Please add PCD File
AL-22-19

RE: 9910 Tomahawk Trail
Project Summary - Special Use Variance

SP1

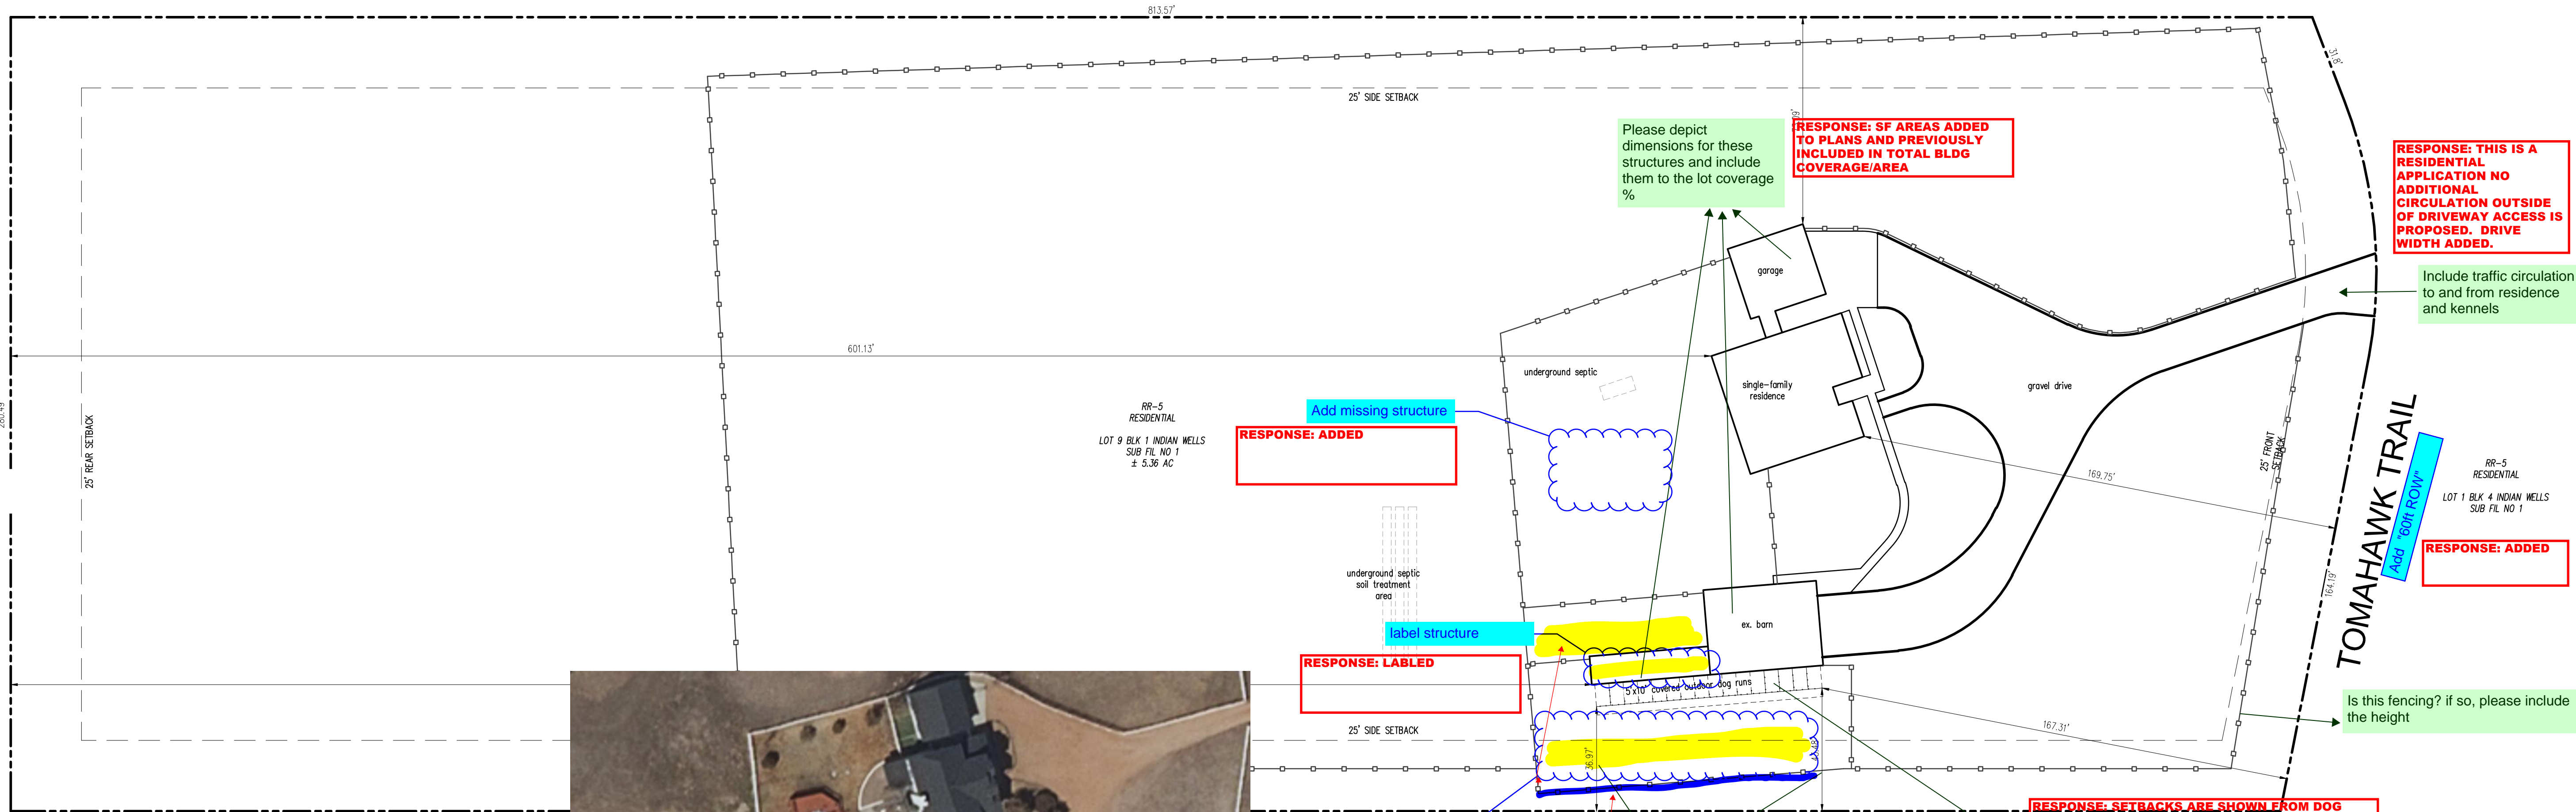
8 of the kennel cages are not attached to the barn

Please discuss the efforts made to mitigate smell, noise, or visual impacts from the kennel being so close

Please discuss the efforts made to mitigate smell, noise, or visual impacts from the kennel being so close

RESPONSE:
These are attached to the attached shed structure that is a part of the barn. Additional labels provided on plan for clarity alongside revisions to text

RESPONSE:
Additional mitigation
narrative provided
